STATE OF NORTH CAROLINA
DEPARTMENT OF TRANSPORTATION

December 20, 2019

Subject: **Modification Request for Section 404 Individual Permit, Section 401 Water Quality Certification and Neuse Riparian Buffer Authorization** for Interstate 40 Widening and Improvements from I-440/US 64 (Exit 301) to just north of SR 1525 (Cornwallis Road), including improvements to NC 42 and SR 1010 (Cleveland Road) in Wake and Johnston Counties, Federal Aid Project No. IMNHF-040-4(139)301; TIP Numbers I-5111 and I-4739, Divisions 4 & 5; Debit \$570 from WBS Element 42346.3.1.

PERMIT DRAWING SHEET 84 OF 125

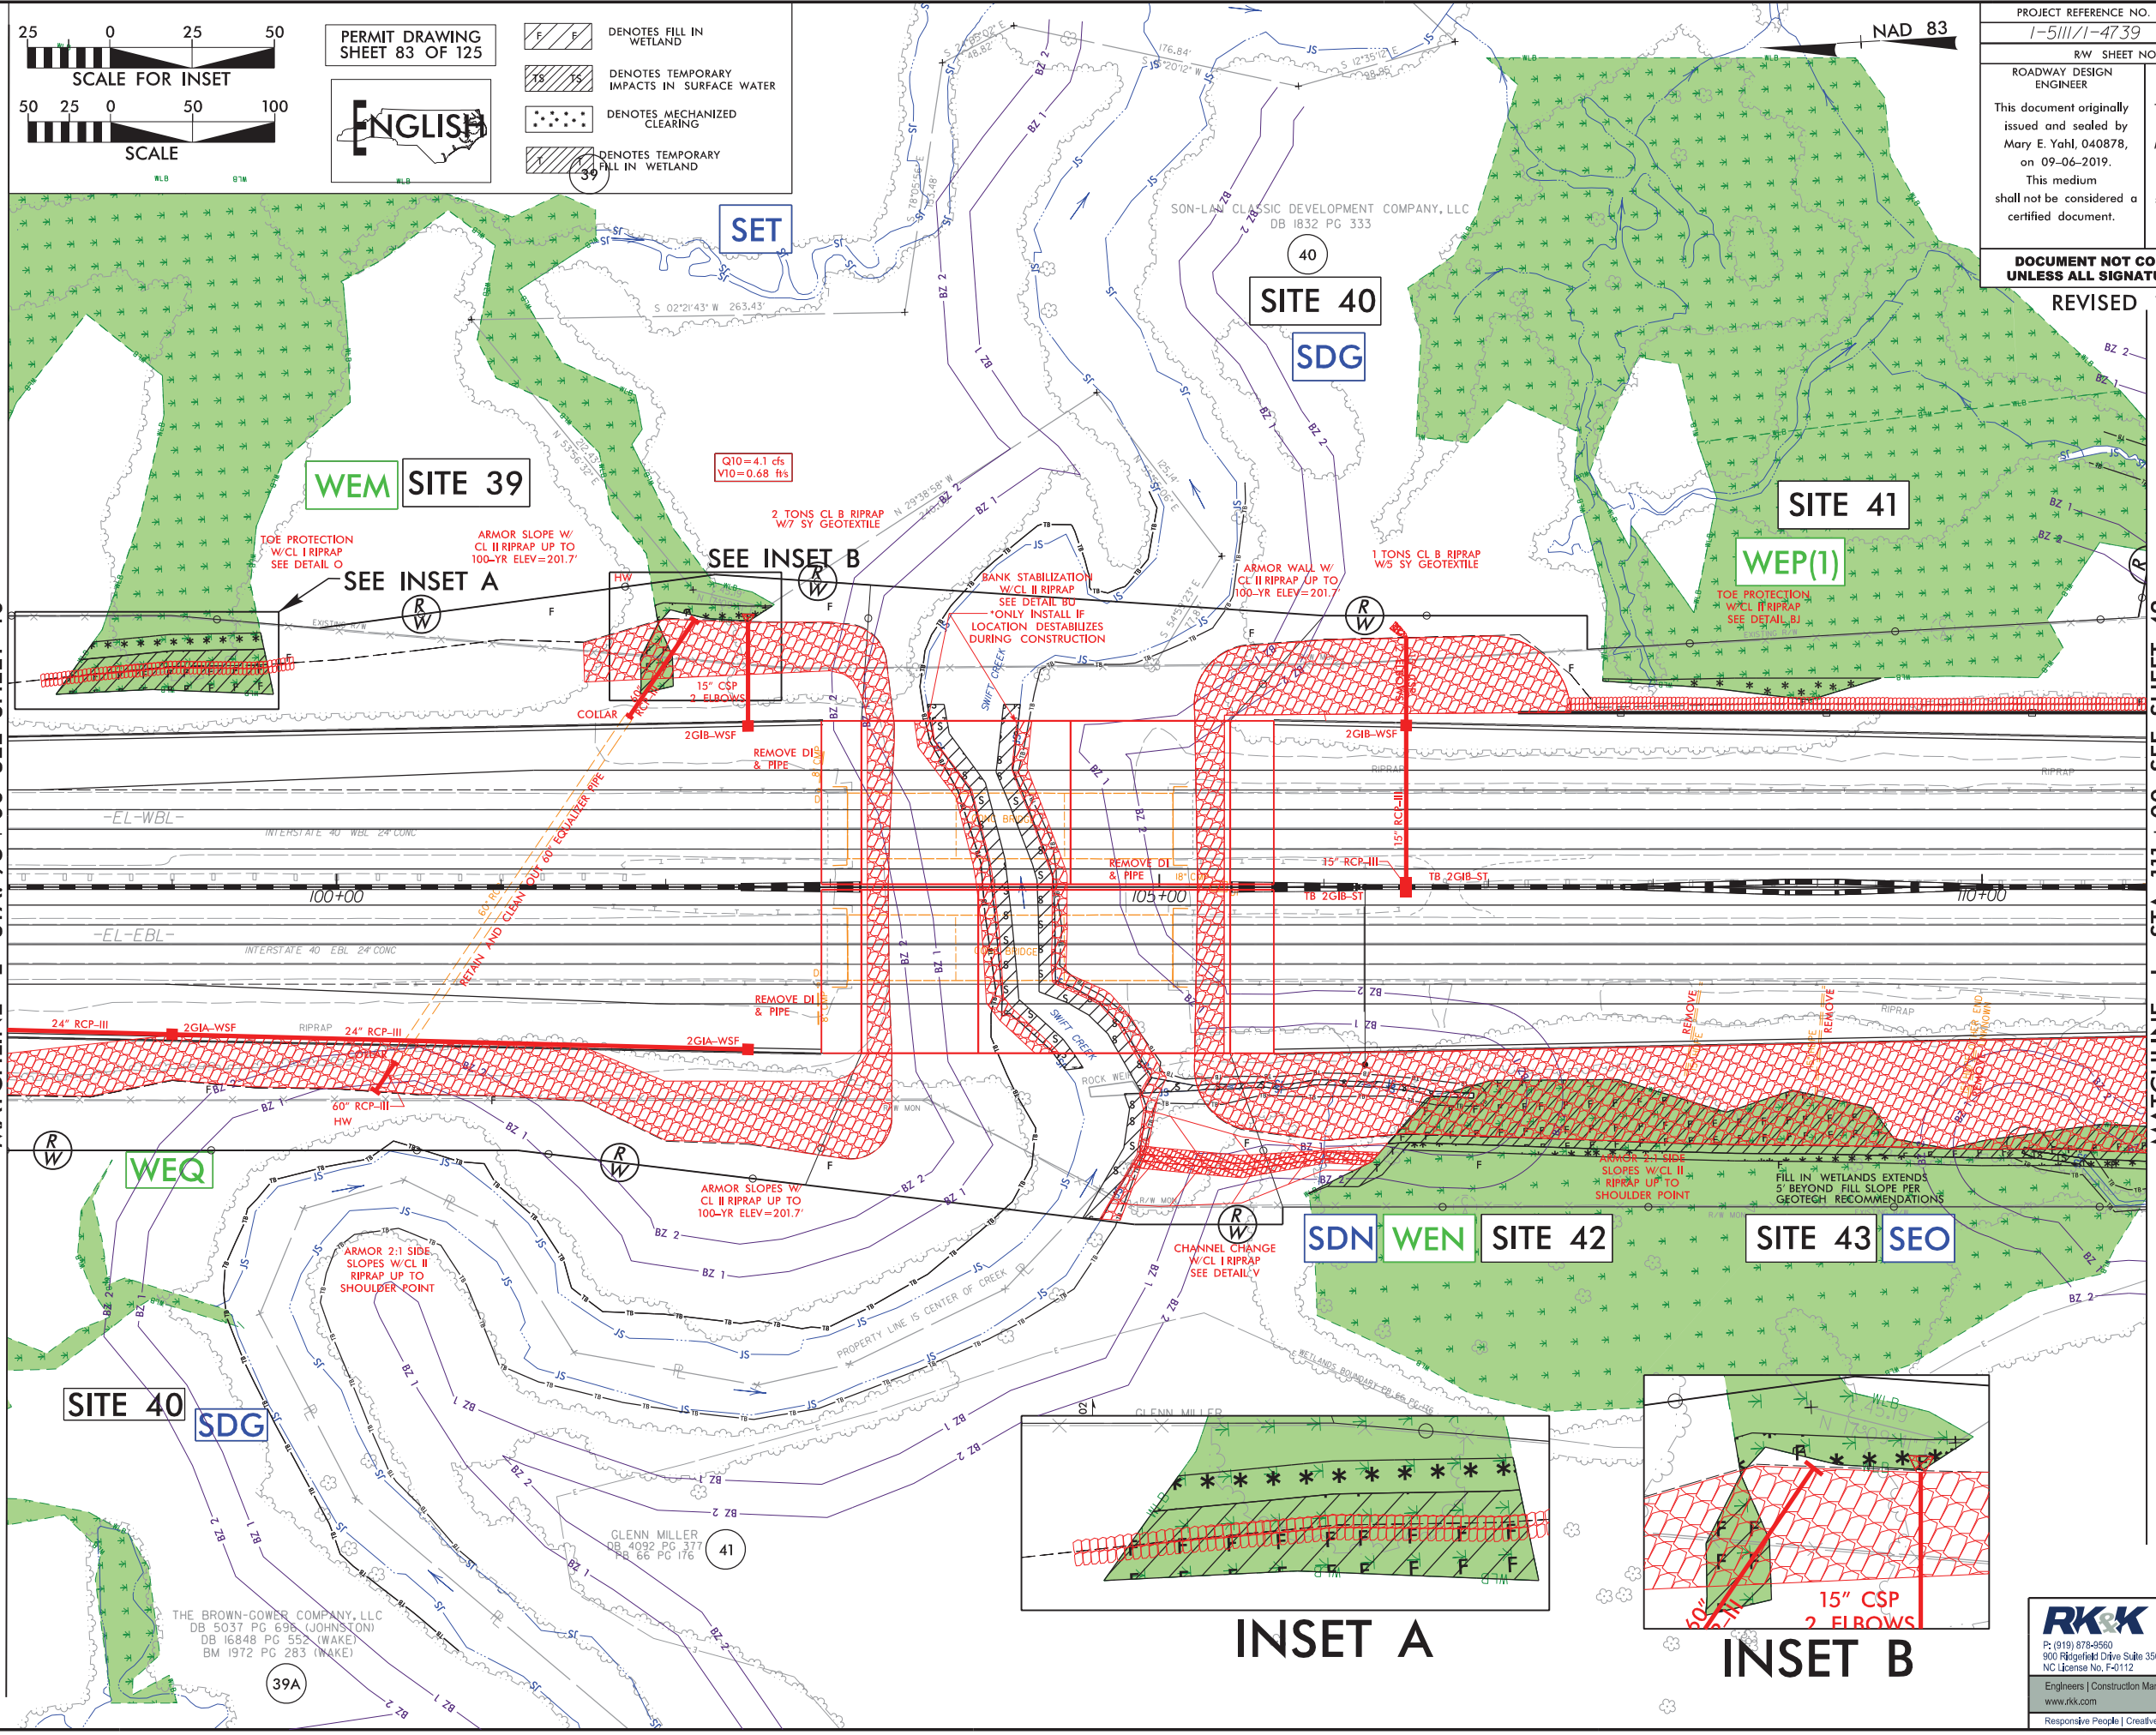
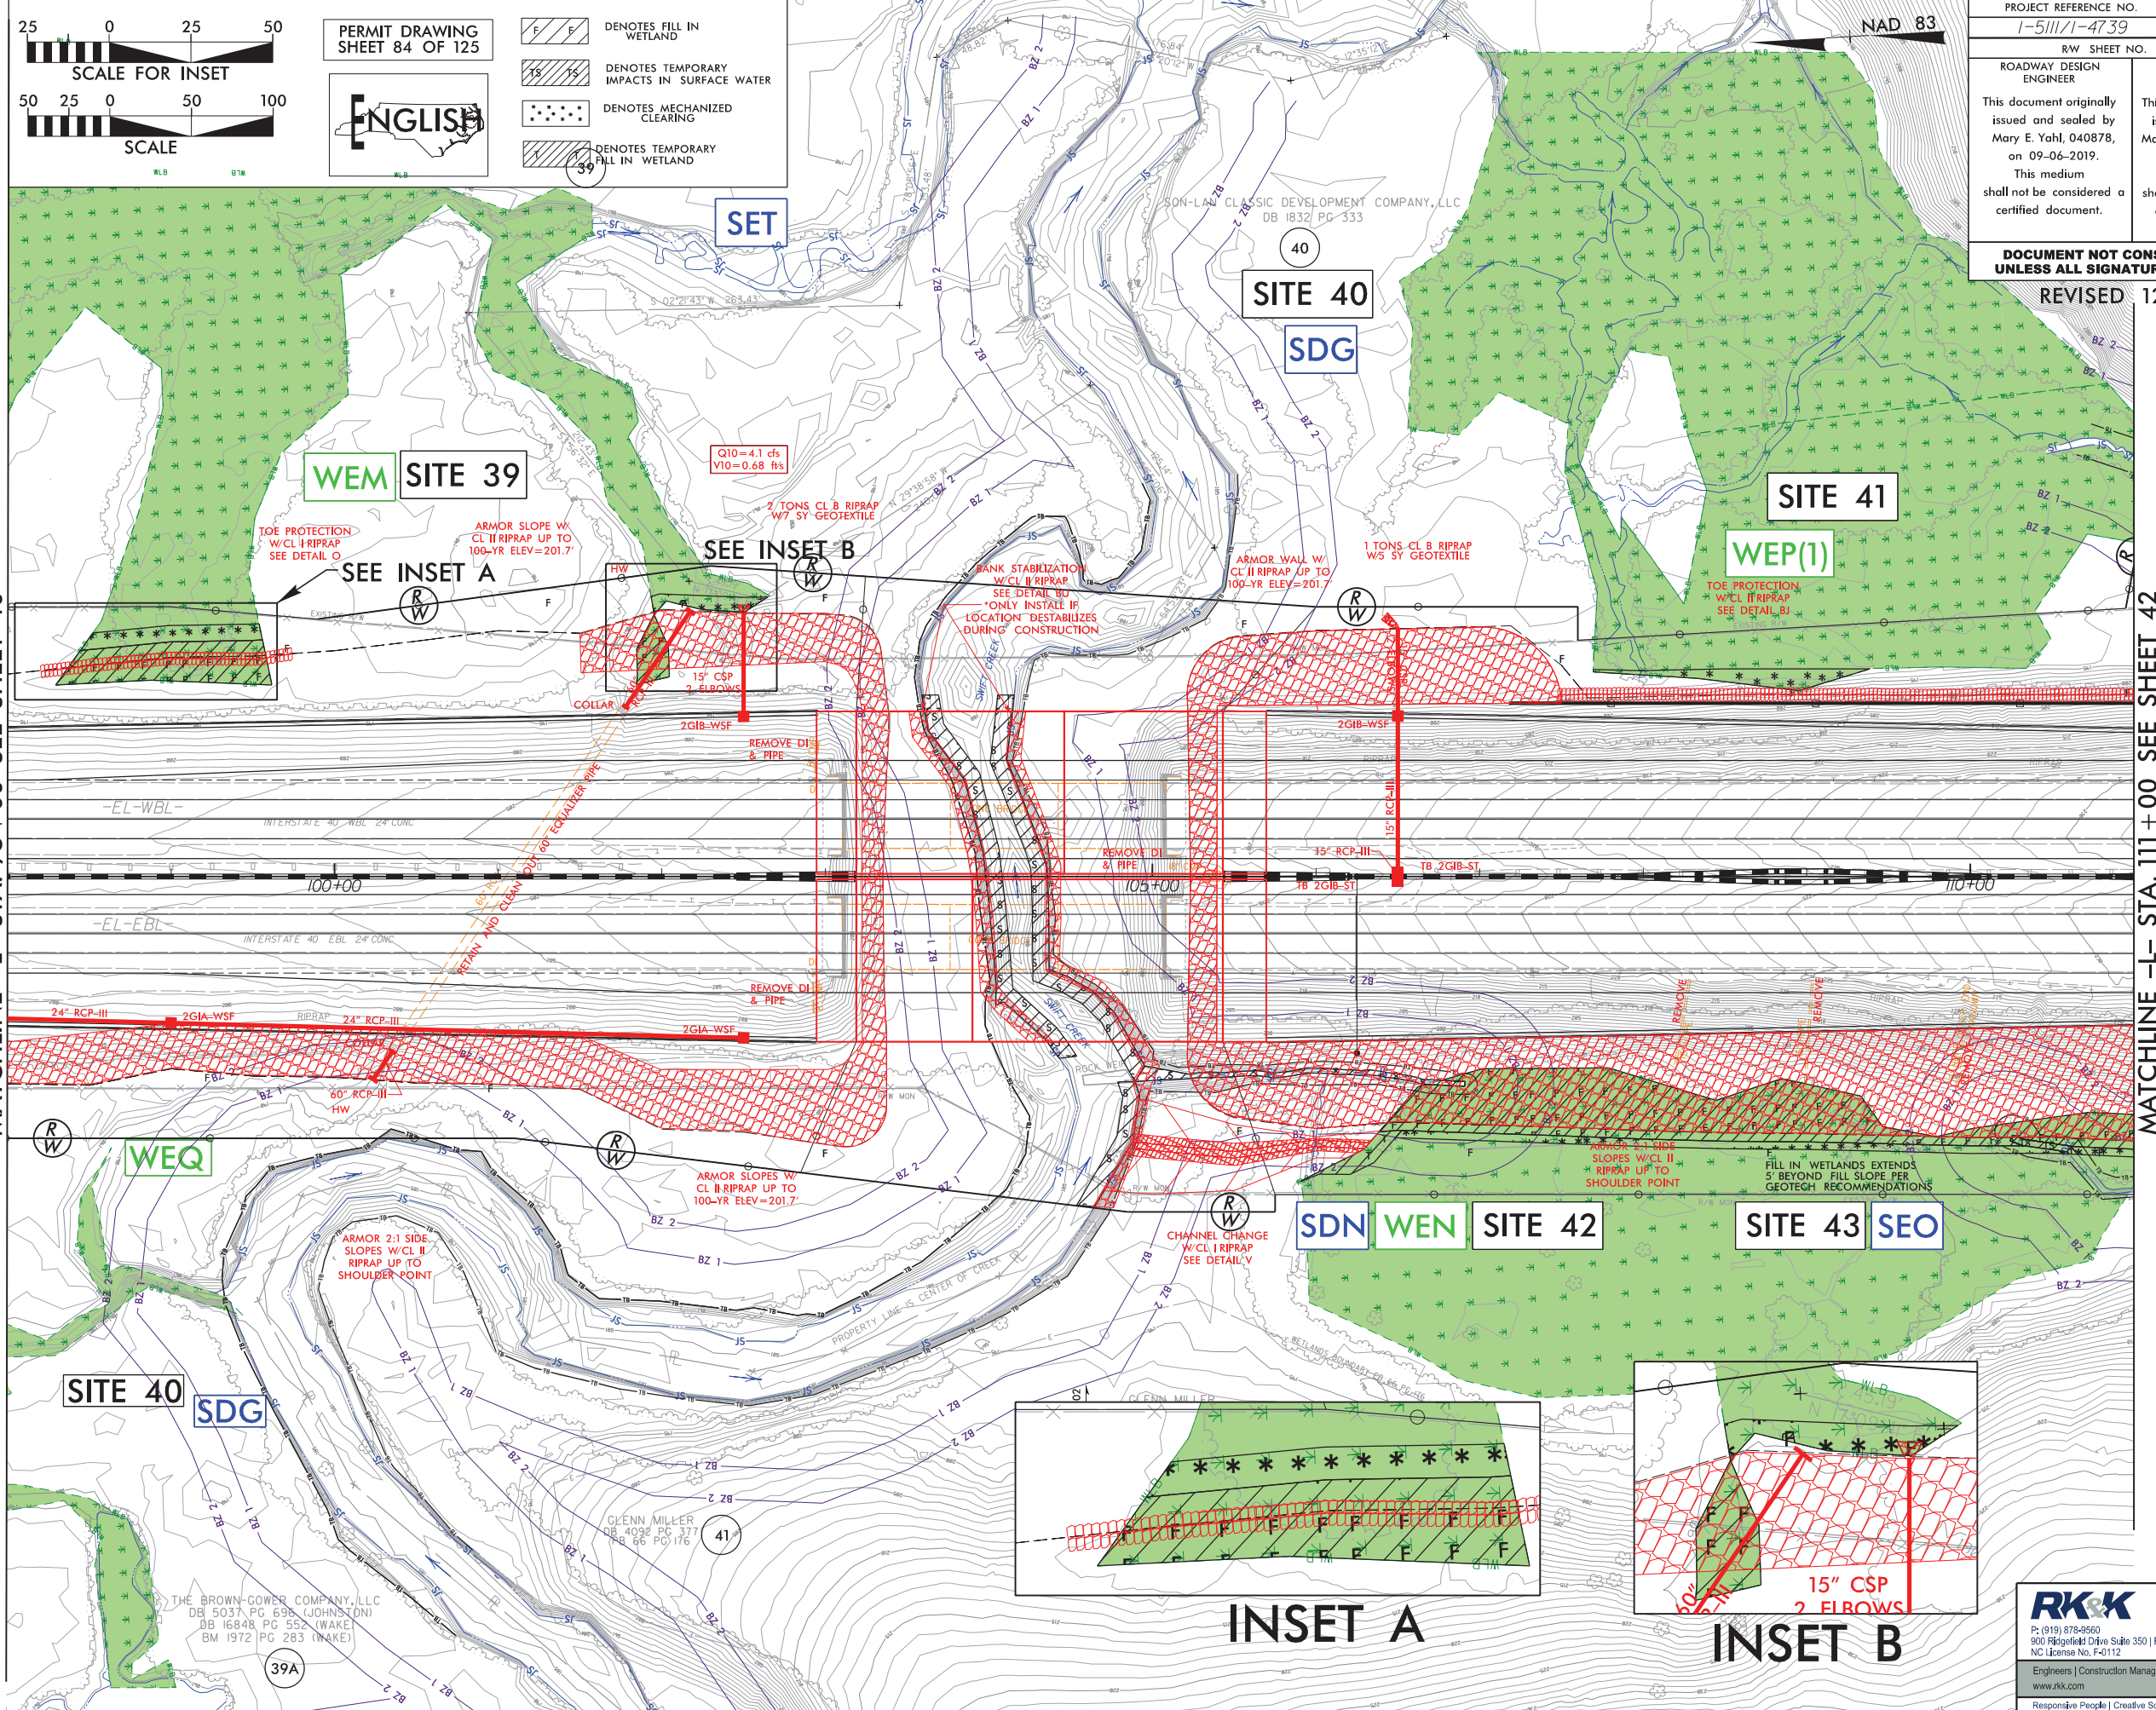
1. Additional buffer impacts at Sites 23A, 23B, and 26A. These revisions reflect additional impacts to mitigable buffer zone 1 areas that the Division requested after field reviewing the top of banks and edge of transportation facility areas at each location. (This information was previously submitted to DWR before the other issues came to light).
2. Changing temporary impacts along the upstream, right bank of Swift Creek, Site 40, to permanent impacts by lining the bank with Class II riprap. This is considered a permanent

stream impact as bank stabilization. Previously it was considered temporary impact under construction and dewatering activities.

3. Site 42, -L- 106+38 – 111+14 RT will change a portion of the mechanized clearing to permanent fill in wetland. This is due to a Geotech recommendation to push riprap into the soft soils 12” – 24” deep in the area of the wetland. This limits the amount of undercutting that will need to occur. The Geotech recommendation states the station range is appr. -L- 110+00 – 125+00. The actual impacts due to the wetland shape are in the station range -L- 106+38 – 111+14. (There is a portion of temporary fill in wetland that will change to permanent fill in wetland, 0.002 ac, but it is so small that it is lost due to rounding). We do not anticipate a draining effect on the wetlands. The relocated channel will serve to function like the stream we are removing (SDN). There will be no voids in the riprap that is installed therefore we do not anticipate a discharge. Soil will be prevalent throughout the riprap.

- Permit drawing 1 of 125: titlesheet
- Permit drawing 83 of 125: plansheet 41 reflecting revisions to Sites 40 and 42
- Permit drawing 84 of 125: plansheet 41 reflecting revisions to Sites 40 and 42
- Permit drawing 124 of 125: summary table
- Permit drawing 125 of 125: summary table

- Site 40: previous permanent stream impact: 254', temporary stream impact: 90'; new permanent stream impact: 334', temporary stream impact: 10'
